Subject: Objection to Planning Application

Formal Objection to Planning Application – 143 Church Lane, Gomersal 2026/62/90484E

Jan 26      1:50,1:100      DWG 02      -

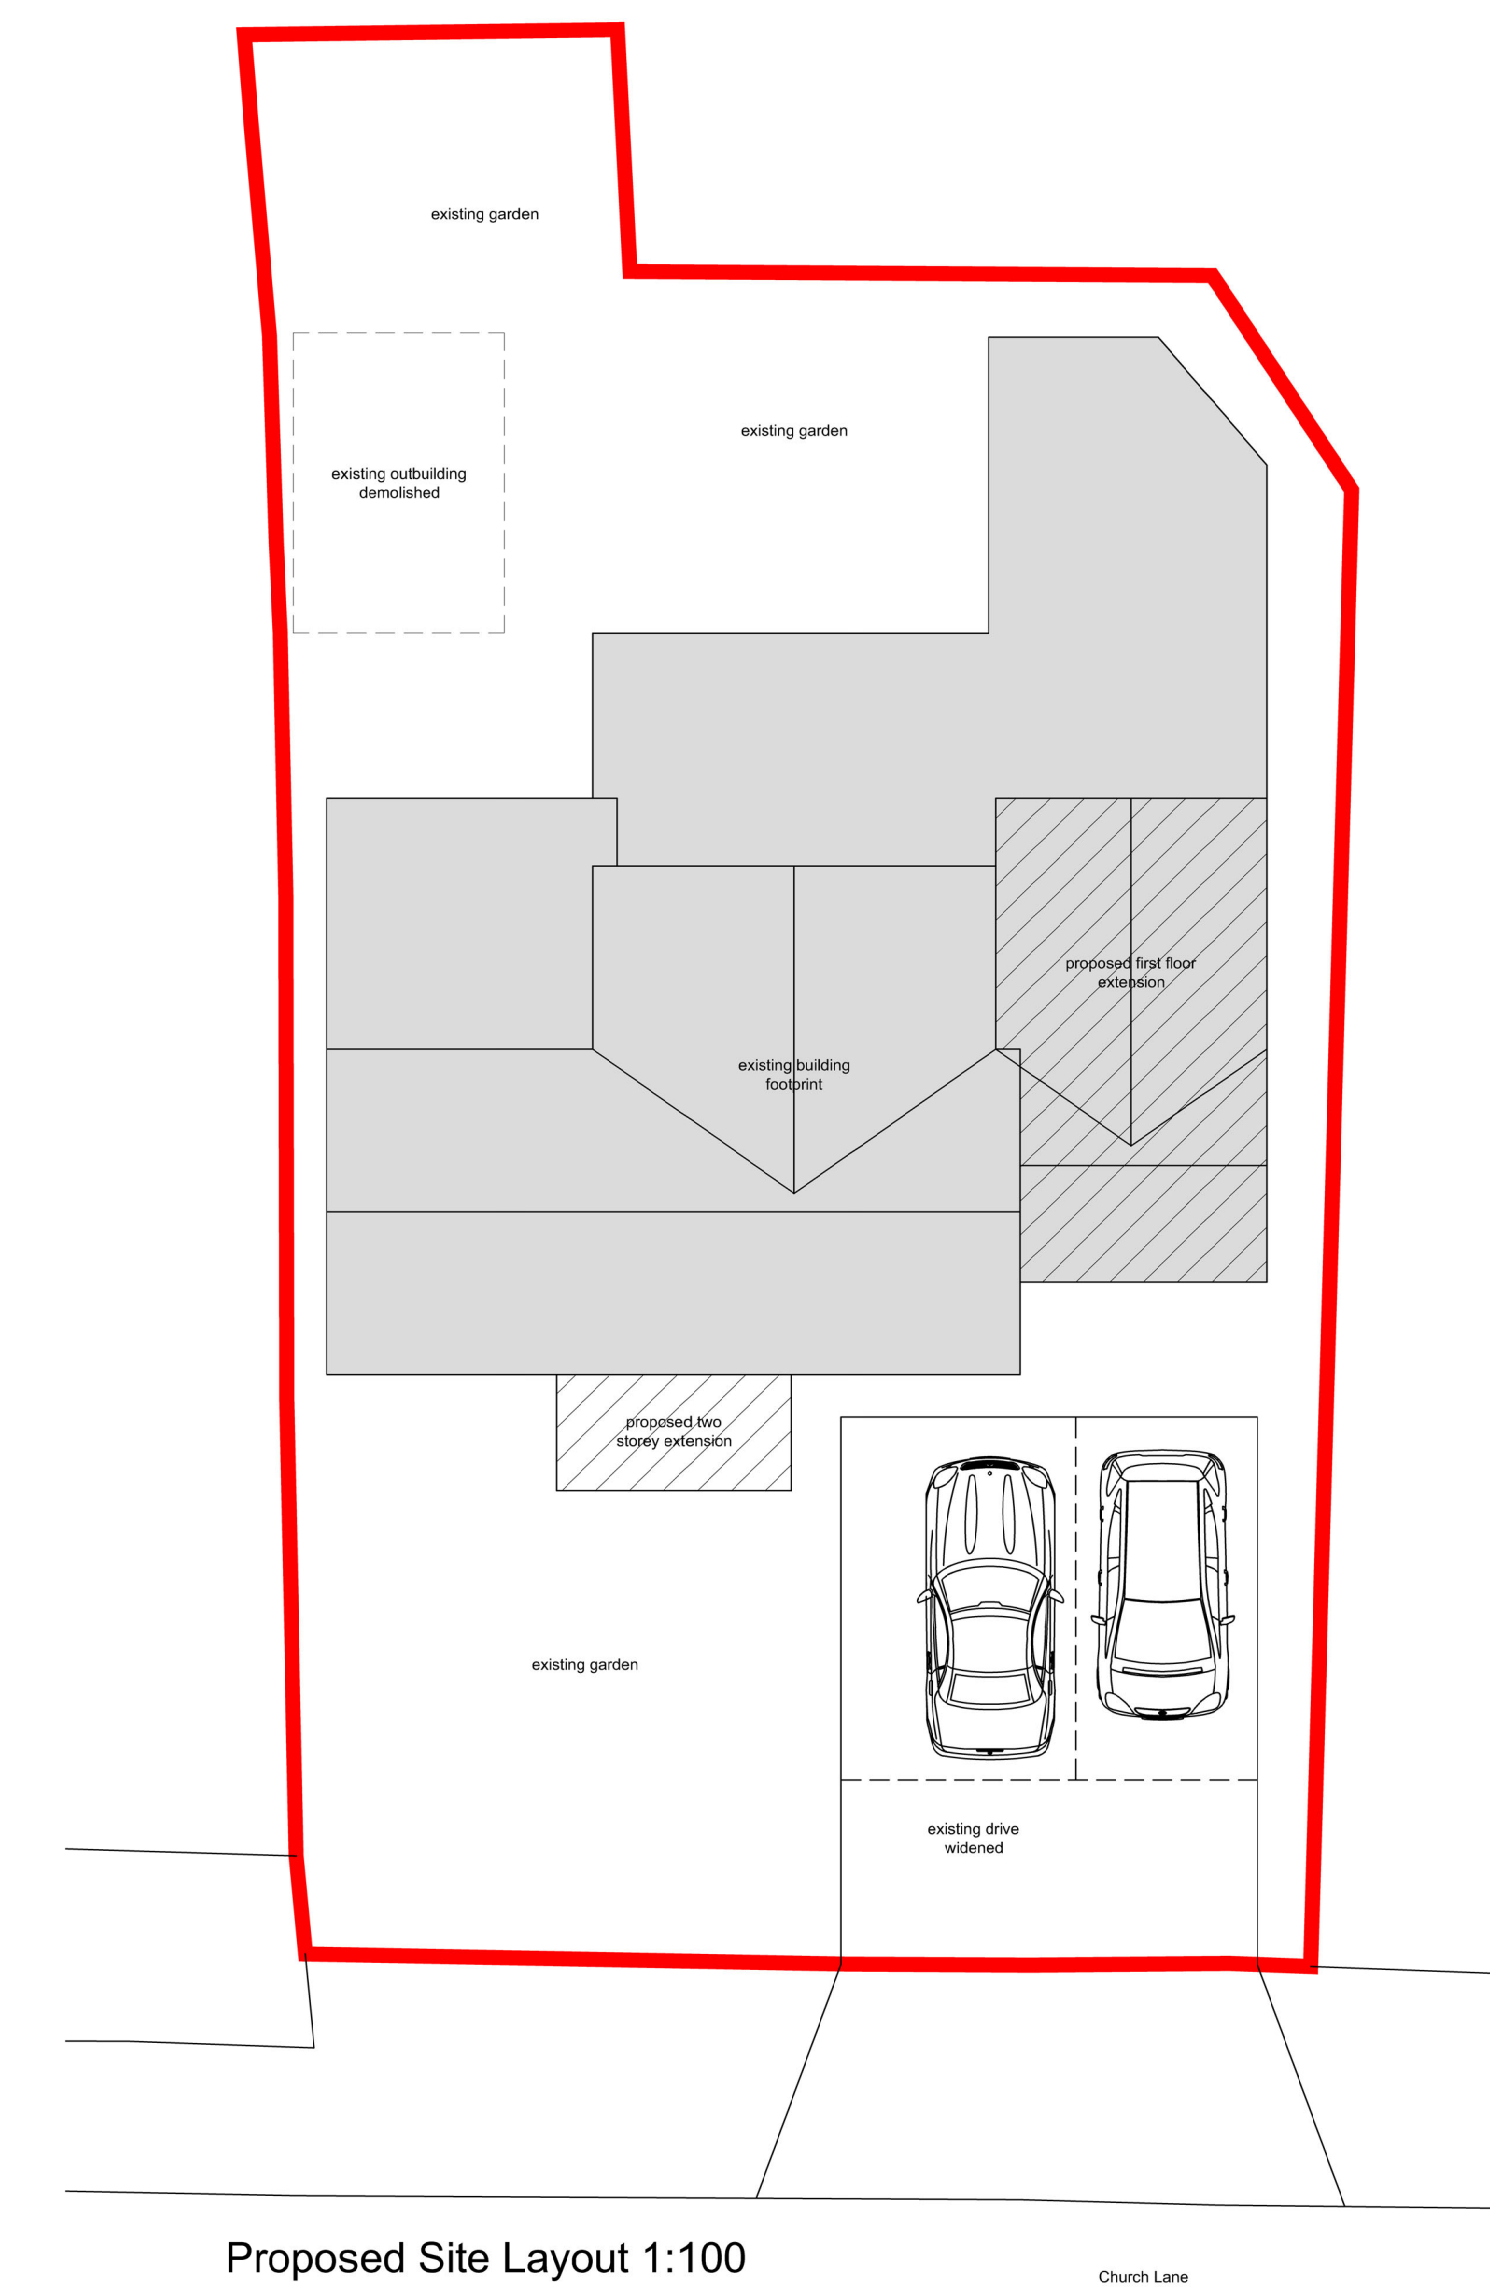
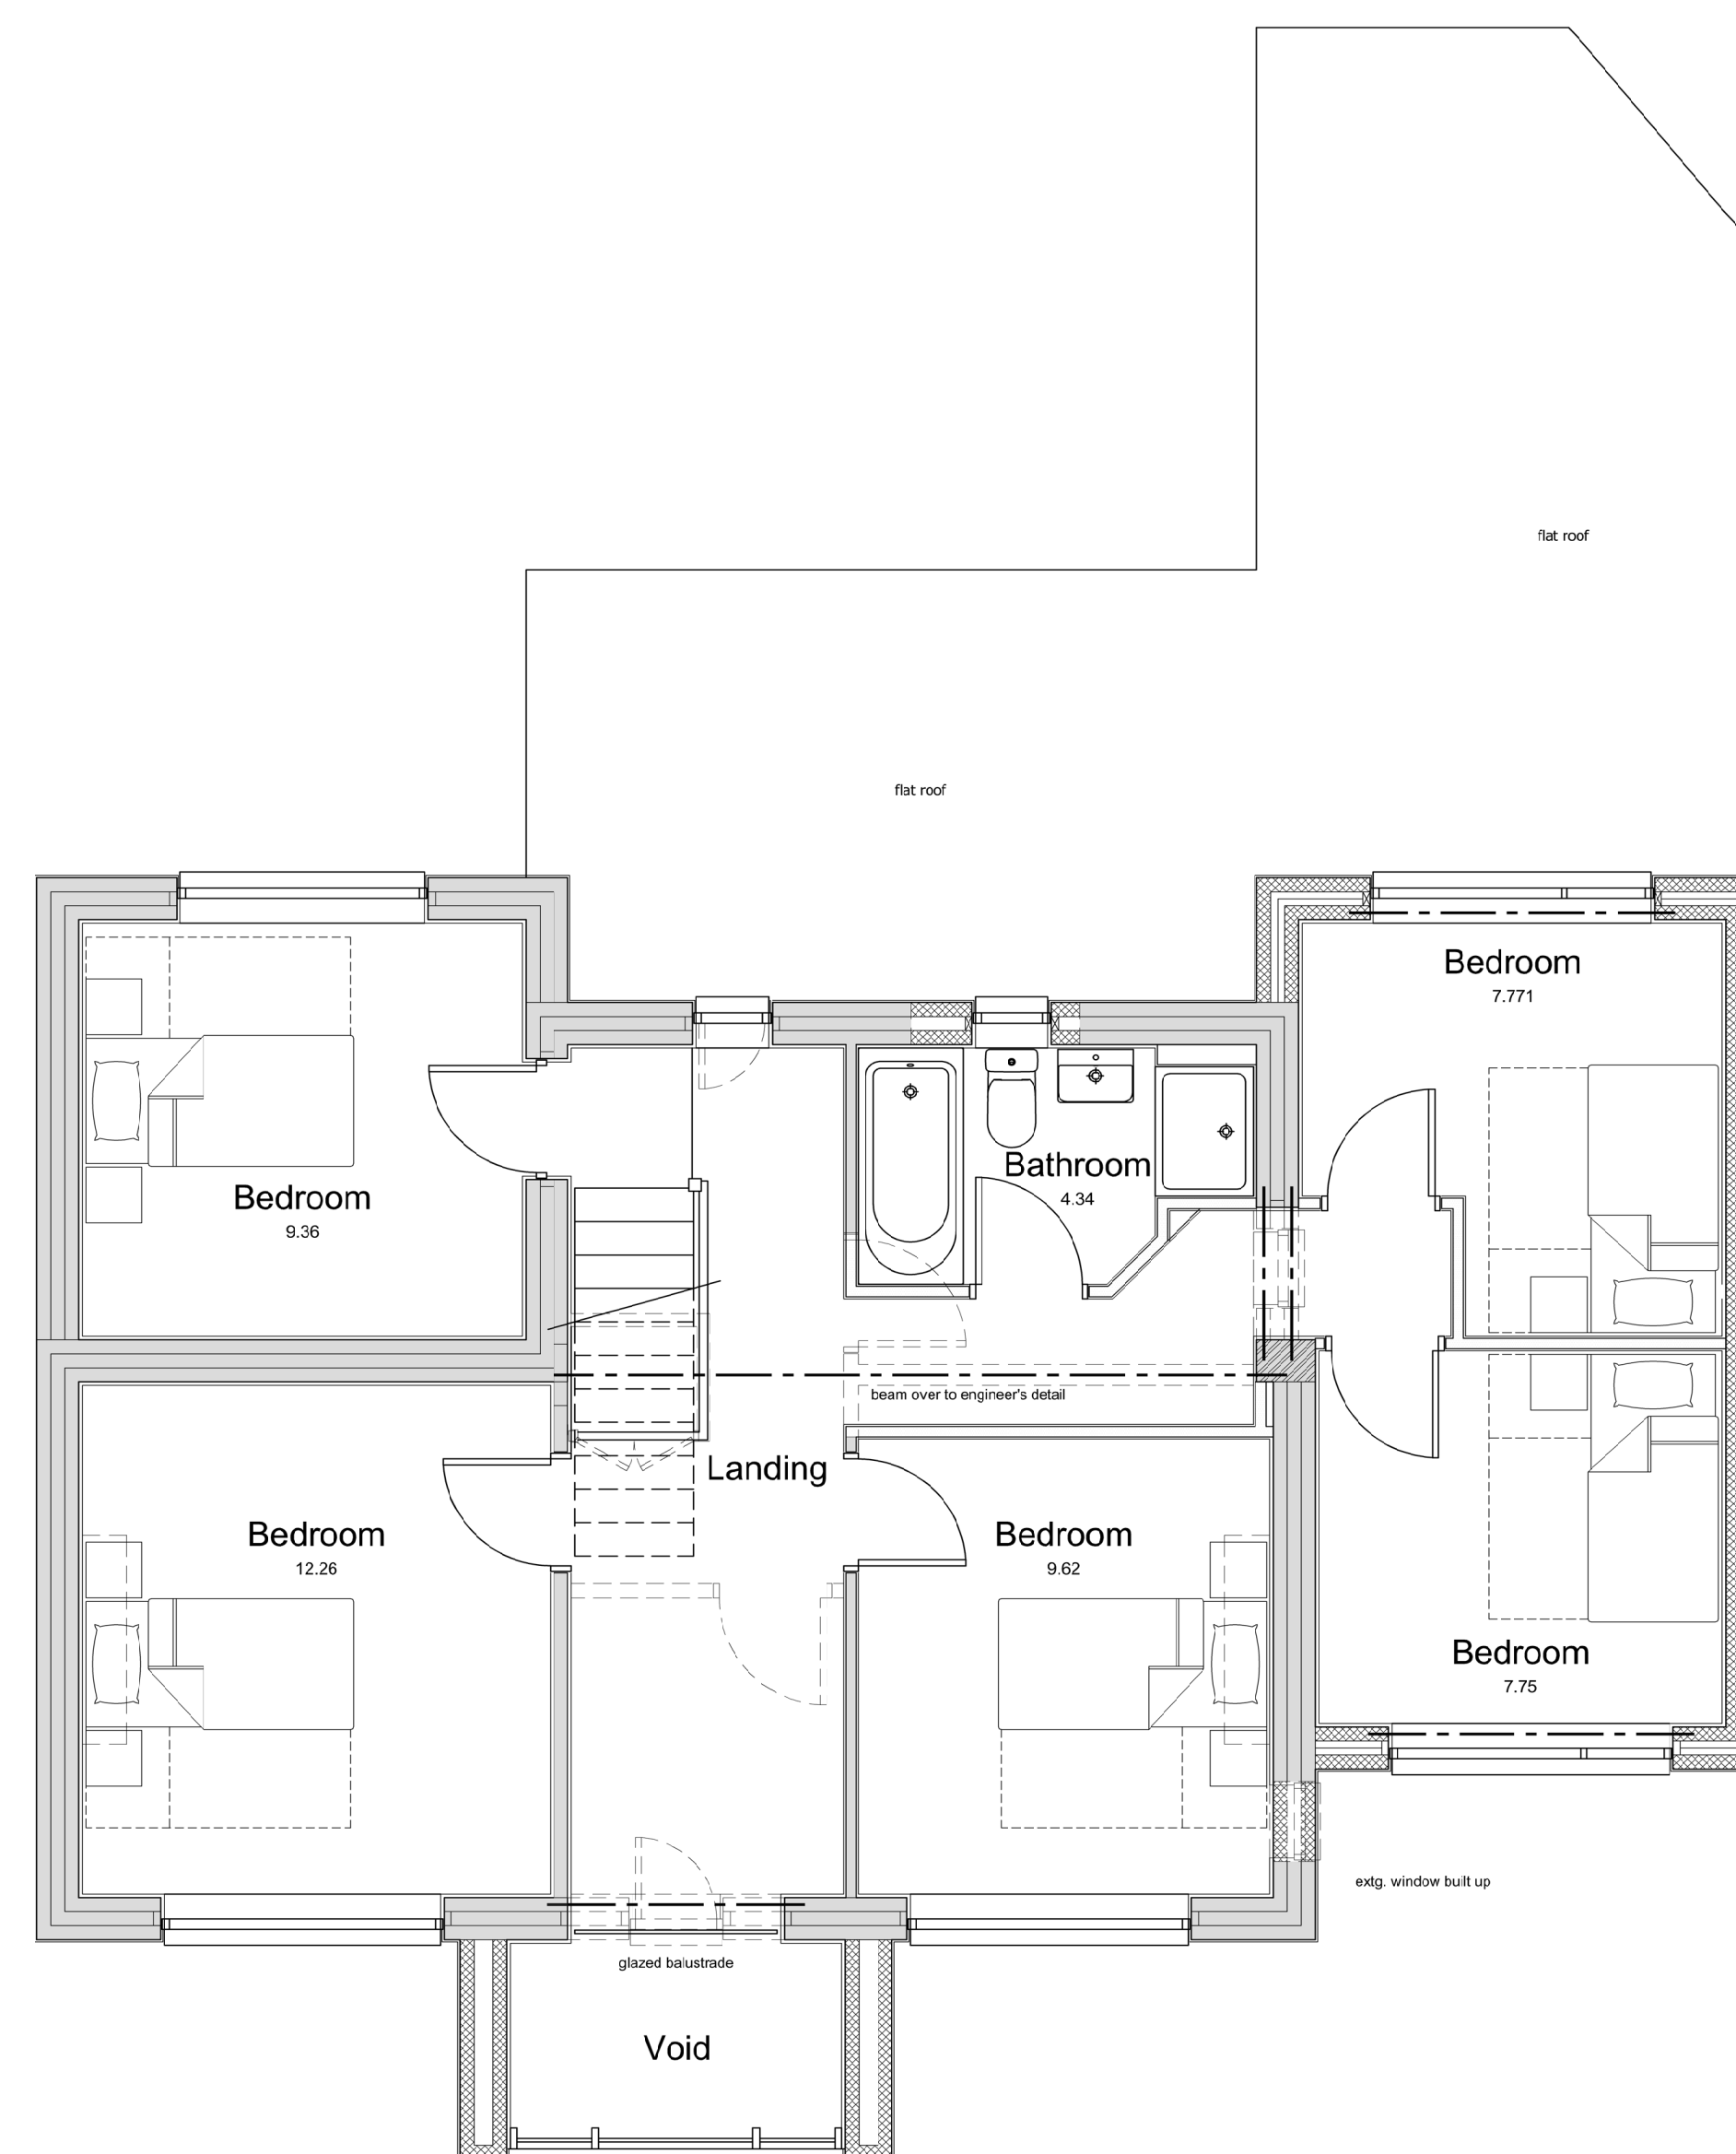
After reviewing the proposed plans and carrying out a visual inspection of the property, it is evident that there are no apparent escape routes from the rear of the building as the side elevation only provides around 750mm of clearance between the existing garage and the boundary line, which is not adequate as an emergency escape route.

Furthermore, the property would require fire-escape compliant windows for all bedrooms. Several of these windows would fall outside the proposed secure fencing and gated areas,

creating significant safety concerns and presenting potential escape risks for vulnerable residents should they wish to leave of their own accord.

The application claims an additional parking space has been created, yet the garage which could have provided parking has been converted into a room. In reality, the property still only offers two on-site spaces.

The plans also indicate controlled gate access for entry and exit. This will further reduce usable outdoor space, in addition to the area already lost to parking.
